Our ref: DOC20/614362

Notice of Exhibition of application for Taronga Zoo – Upper Australia Precinct (SSD 10456)

Thank you for your referral dated 30 July 2020 inviting comments from the Heritage Council of NSW on the above State Significant Development (SSD) proposal.

Figure 14 | Photomontage of proposed fence along Bradleys Head Road (Source: Applicant)

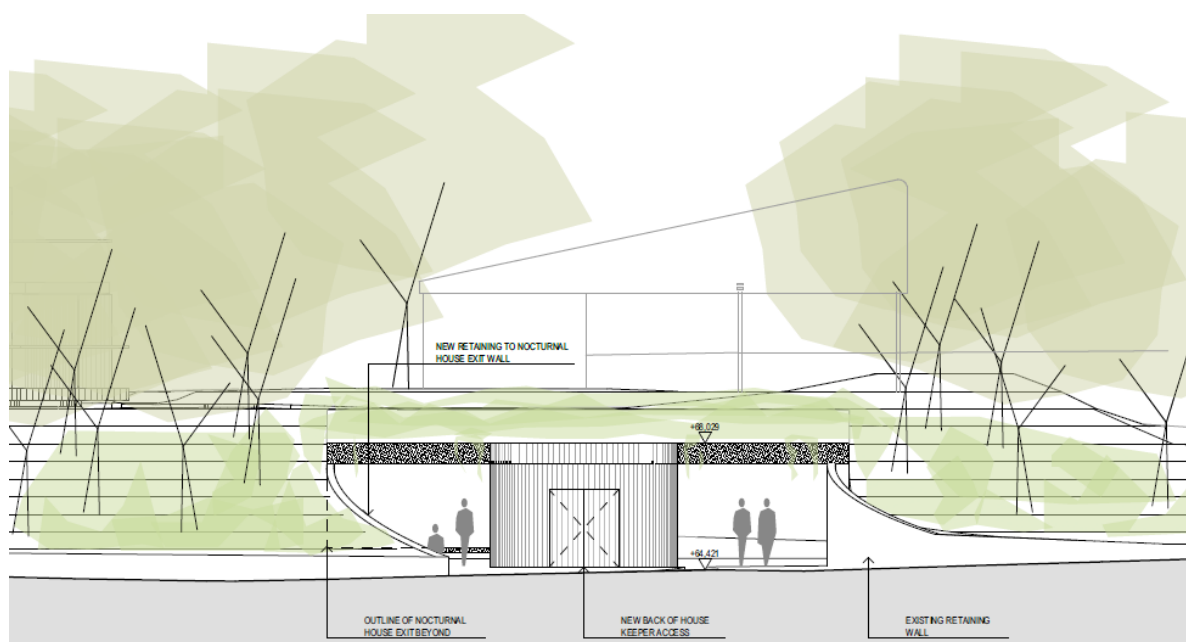
The interface of the new fencing partition along Bradleys Head Road to an exceptionally significant sandstone boundary wall, is proposed to be managed through design elements such as natural materials and colours. The application has not included information to demonstrate the proposed approach to manage the interface with this significant part of the site, particularly where an irregular fence height has been proposed and it is an externally viewed element.

Submission of additional visual information (e.g. photo montage and design palate) at response to submission stage would better demonstrate the proposed approach envisaged to managing the change to this part of the site (new fencing along Bradleys Head Road). This information is likely to assist Council in their comments.
